Our Ref: 1-046/002
31 March 2021

RE: NORTHAW HOUSE, HATFIELD – RESPONSE TO HERTFORDSHIRE LEAD LOCAL FLOOD AUTHORITY CORRESPONDENCE (REF; 6/2021/0072/MAJ, DATED 15 FEBRUARY 2021)

We have now reviewed David Uncle (from Hertfordshire LLFA) comments as provided under correspondence 6/2021/0072/MAJ, dated 15 February 2021. Each of the queries raised and our responses to each query is provided below;

Trapped Gully Detail (1:20)

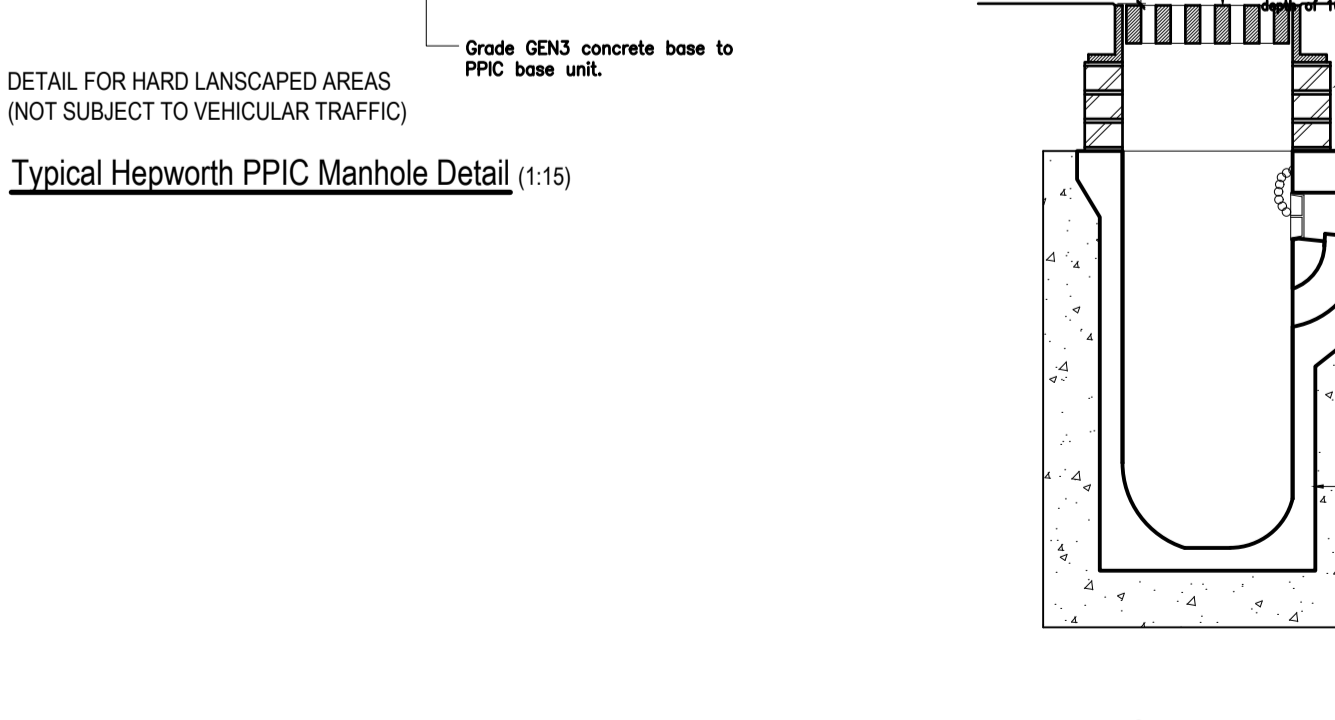
“Please could the applicant also clarify how the swale north of this eastern road connects to the wider drainage network to be discharged.”

The swale to the north of the access road will not be positively drained. The reason for this is due to the swale going against the natural topography resulting in excessive invert depths (around 3m deep) resulting in large earthworks. The swale will still provide an exceedance flow function however and hence why it is still shown on the plans. The road area in question will drain via a trapped gully system connected to pipes 12.000 and 12.001.

Section C-C - Typical Dry Swale Detail (1:20)

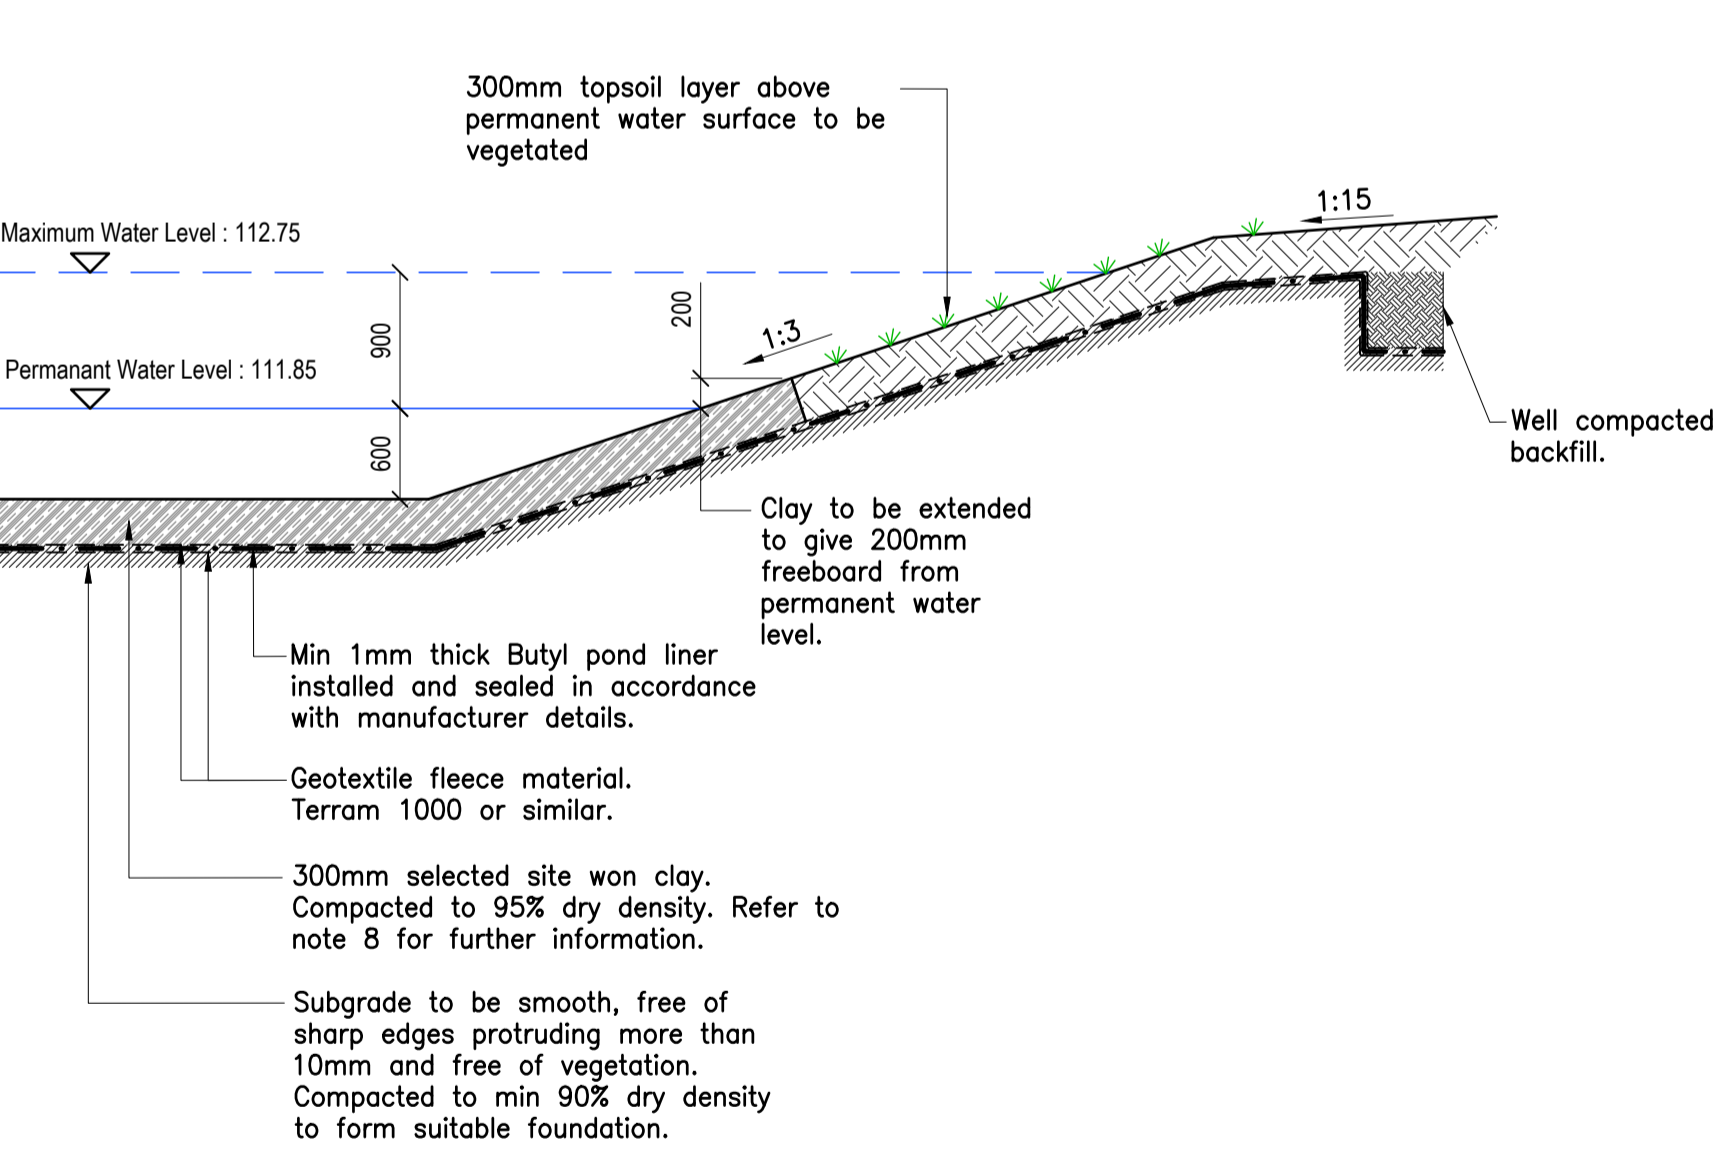
2. *“We note the surface water pipe runs in the eastern road (pipes 12.000 – 12.001). Please could the applicant clarify how runoff from this part of the system will receive SuDS management and treatment before entering the pond”*

- “The applicant has provided calculations for the 1 in 100 year + 40% climate change event and confirms that the basin size has been increased to provide a total volume of 1305 m³. The applicant has provided post-development network calculations including half drain down times indicating the basin will take approximately 27.13 hours to drain down to half during the 1 in 100 year + 40% climate change event. However, we require half drain down times to be less than 24 hours or evidence that the proposed network can manage for a 1 in 100 + 40% climate change storm followed by a 1 in 30 year event.”*

Based on the above the access road discharging directly into pipes 12.000 & 12.001 which in turn discharge to the pond is acceptable in accordance with best practice contained within the SuDS Manual (C753). Indeed, the mitigation provided within the pond alone is far in excess of the minimum requirements.

There is a total of 1,305m³ available within the pond, allowing ample storage for both the 30+0%cc event and 100yr+40% climate change to occur consecutively.
